BARRY SMITH CBE BA IP NUMBER [REDACTED]

## FOSSE GREEN DEADLINE 4 SUBMISSION

The following section refers to REP3-037 Solar Technical Guide (Revision 2). Paragraph references and quotes in italics refer to this document.

Plate 12-1: BESS imports solar during the day and exports in the evening

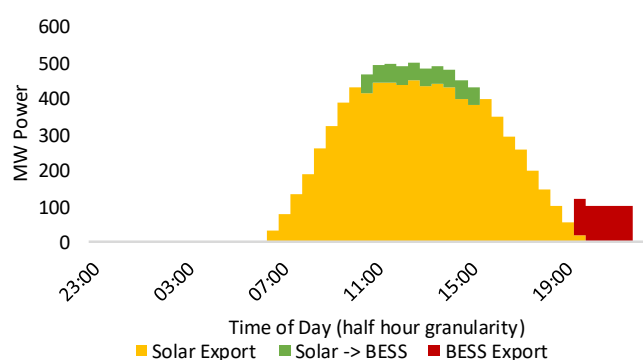
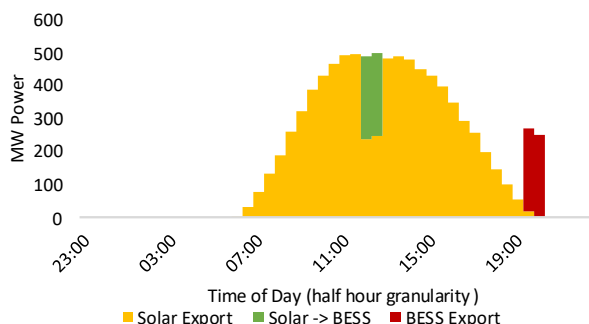
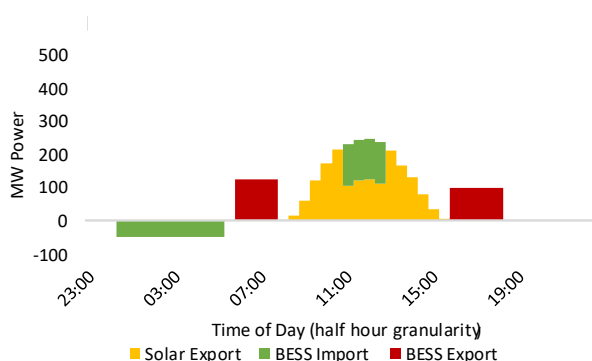
10. Battery Storage Modelling Unbalanced and Incorrect. All the BESS examples provided show summer-like conditions; no seasonal variation is presented. The Applicant's earlier claim that the battery will "only store and discharge energy generated by the Proposed Development" is also incorrect.

B.2.1 REP3-037 Section 12. In response to the ExA requesting an explanation of how the battery storage element is managed, including the most efficient way to utilise battery storage, noting seasonal variation, weather variation and how that relates to when there may or may not be much solar generation in the electricity system, Plates 12-1, 12-2 & 12-3 all show a yellow area depicting solar being exported. If solar is being exported to the grid it can only come from the solar arrays associated with the development. Plates 12-1 and 12-2 appear to be at the height of summer during the 5% of the year when maximum output is predicted. Plate 12-3 which shows 'solar export' peaking at above 200MW is clearly not in winter. A more balanced view is required; for example a monthly plot across the year.
